**Subject: 1st Review Completion Letter
Koneru Short Plat, File No. SUB21-008
PACE Project No. 21436**

We are pleased to submit this letter and the accompanying documents in support of our proposed development of Koneru Short Plat. These submittal documents are provided in response to a review completion letter issued by City of Mercer Island on April 13, 2022. Review comments contained in that letter are provided below (plain text), along with a response (***bold italics***) indicating how each comment was addressed.

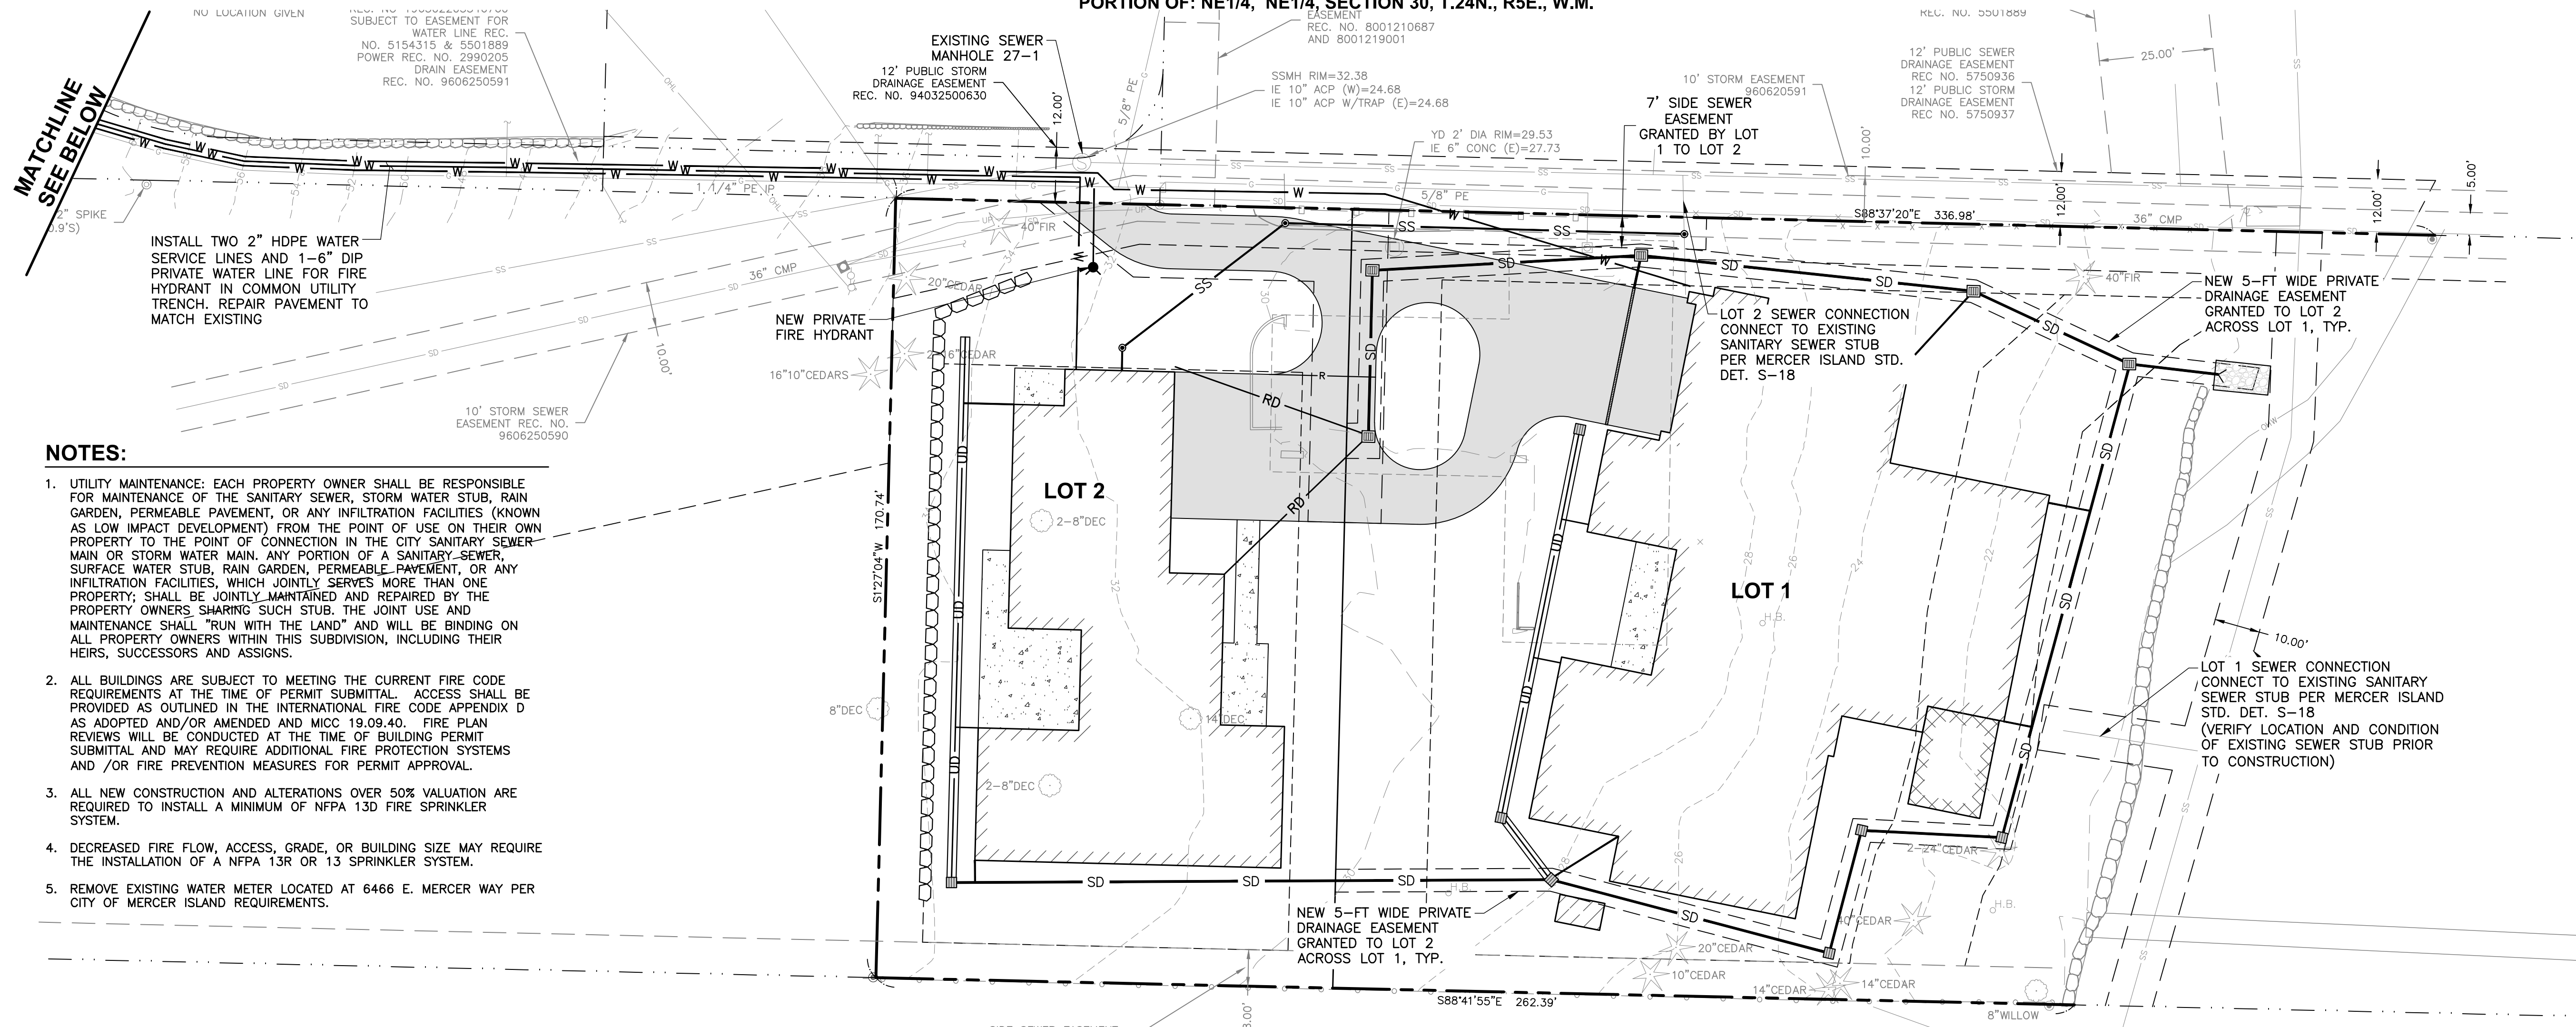
g. Provide side elevation drawings of the proposed driveway. Label existing and finished grade.

a. The existing house will need to be demolished prior to Preliminary Short Plat approval or a condition of approval will be added that the existing house shall be demolished prior to Final Plat application. Please state when the existing house will be demolished. Permit #2112-250 is for a demo/rebuild.

PACE Response: Additional finished grade spot elevations have been added on C2.0 to better define the driveway grading. The driveways design grades are less than 5% slope, which is relatively flat. Profiles can be added to the final construction drawing, if required.

PACE Response: Note has been added to Sheet C0.0 and C2.0.

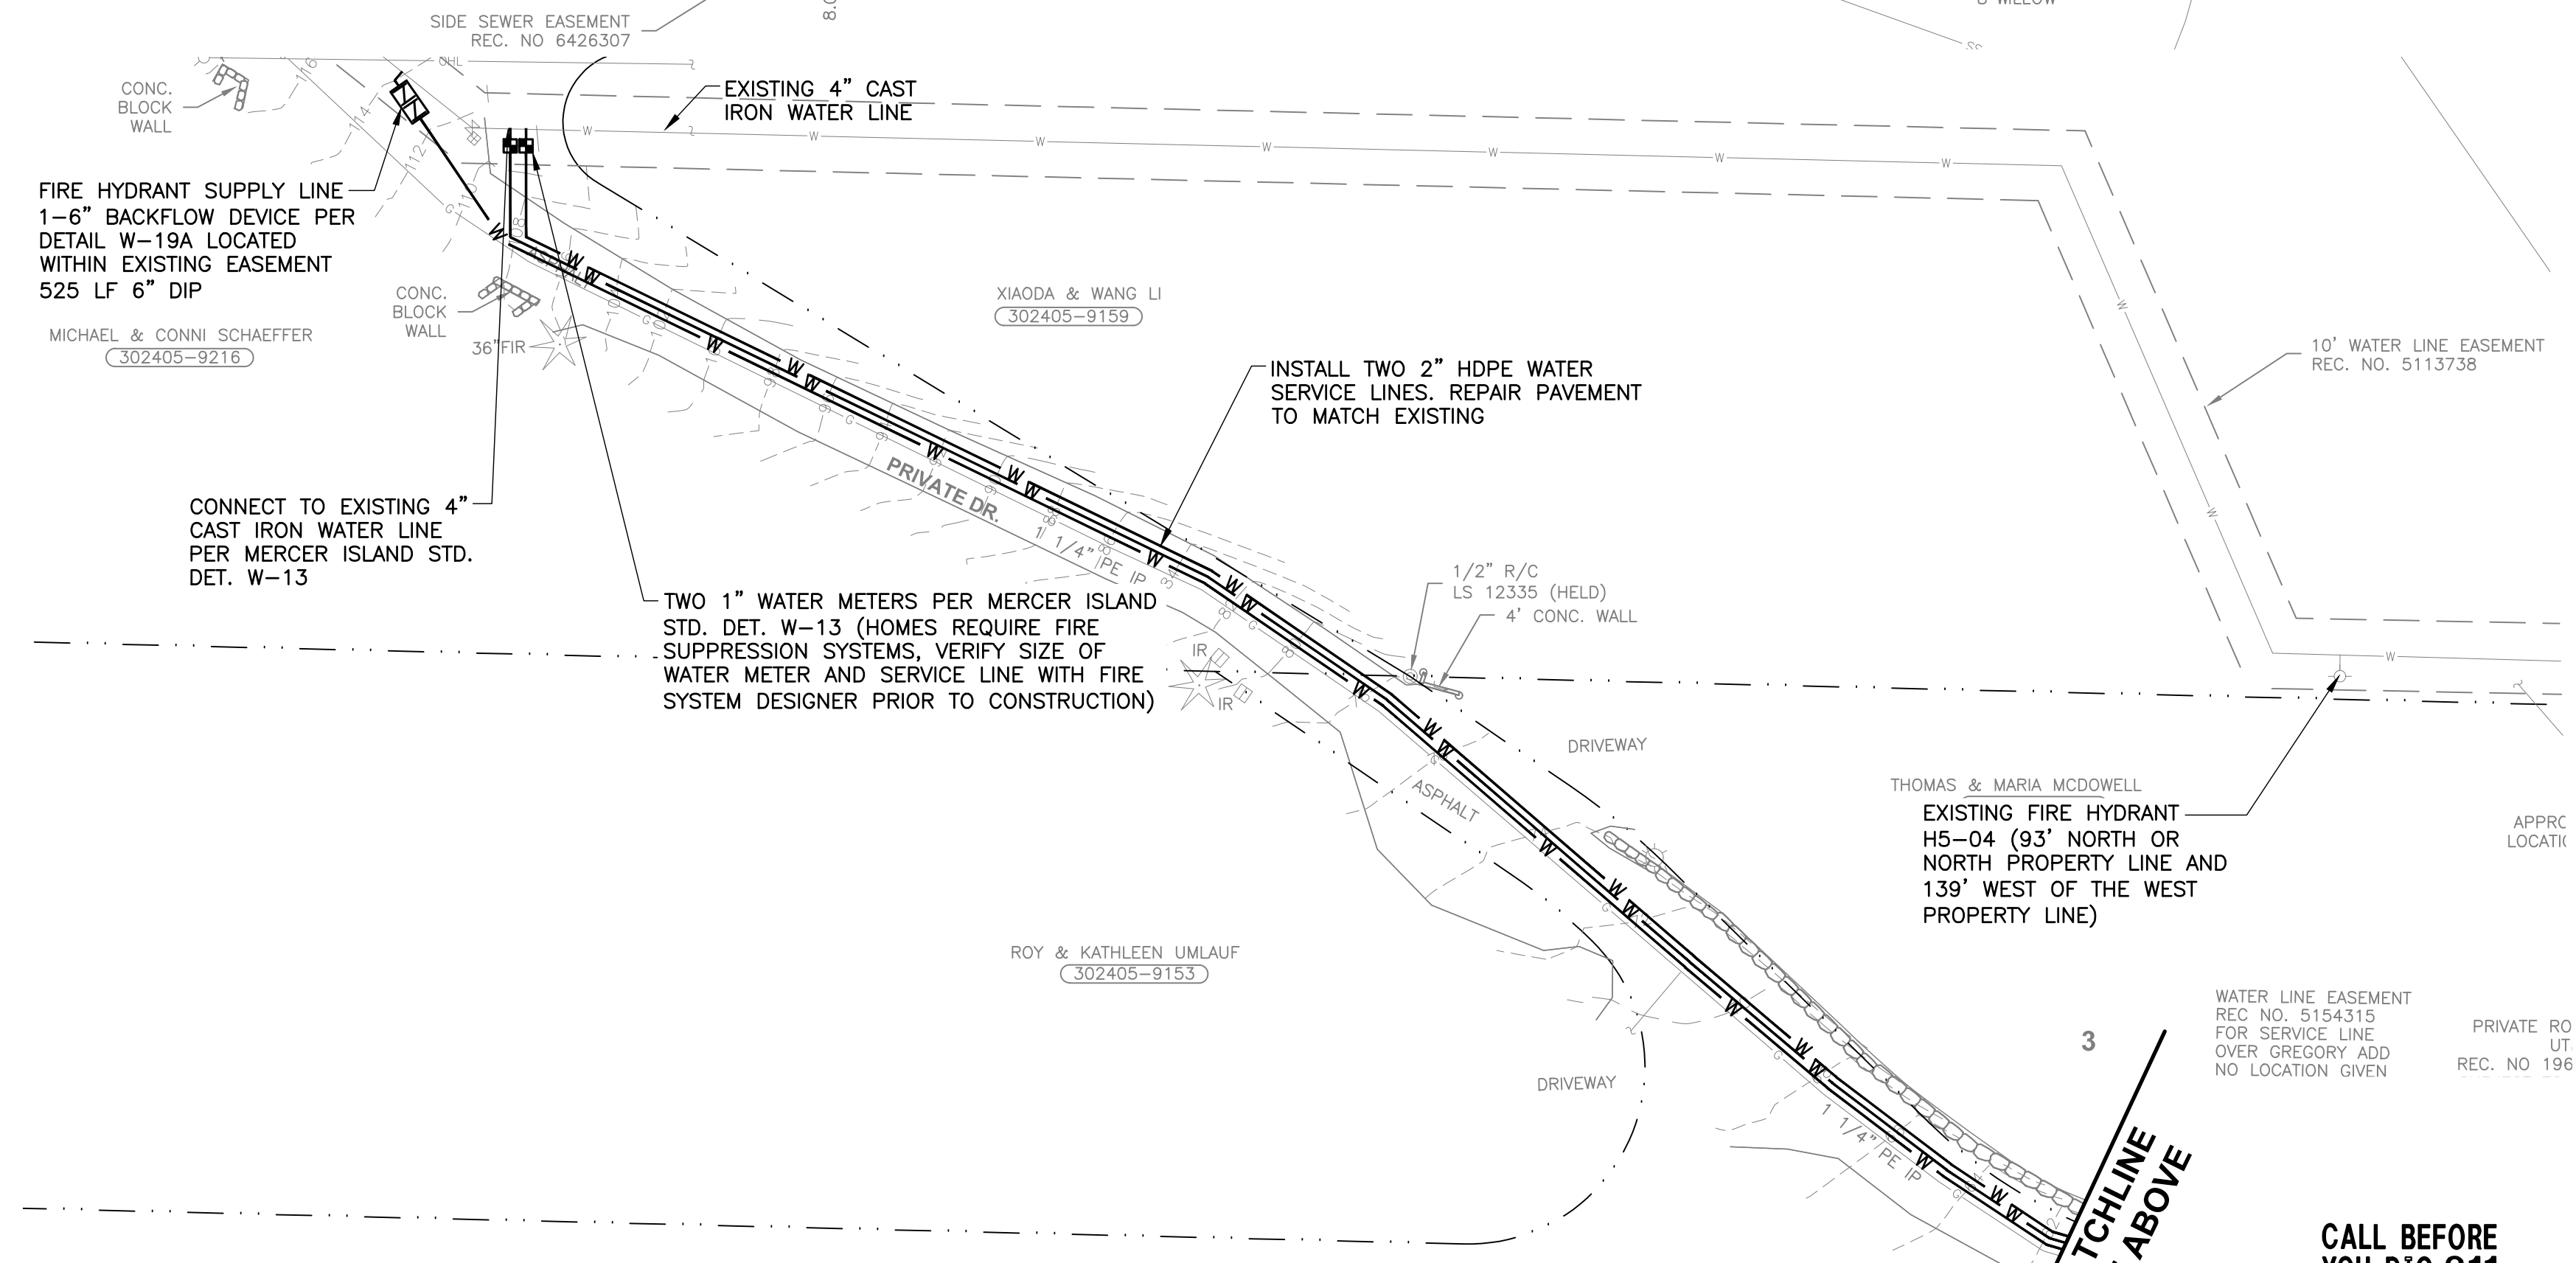
4. (For Civil and Arborist) A tree protection plan with all Civil information must be created. No tree protection is shown on C3.0. The retaining wall, trench, and other utilities to be moved outside saved trees driplines/limits of allowable disturbance. The SD is shown within 9' of exceptional

- a. Show the limits, type, and recording number of the private easement that the proposed private water supply lines will be located.
- b. Show the public water main easement at the new water meter locations. Please note that the water meters and water service lines must be located inside the public water easement.

PACE Response: Sheet L1.0 has been updating to show tree protection fencing for existing trees to be retained. The utility design and tree protection has been coordinated with the project arborist.

PACE Response: The private water lines will be located within the plat access/utility easement road, which is not well defined in any of the records. The existing water easement for the 4-inch main and water meters has been added and recording number called out.
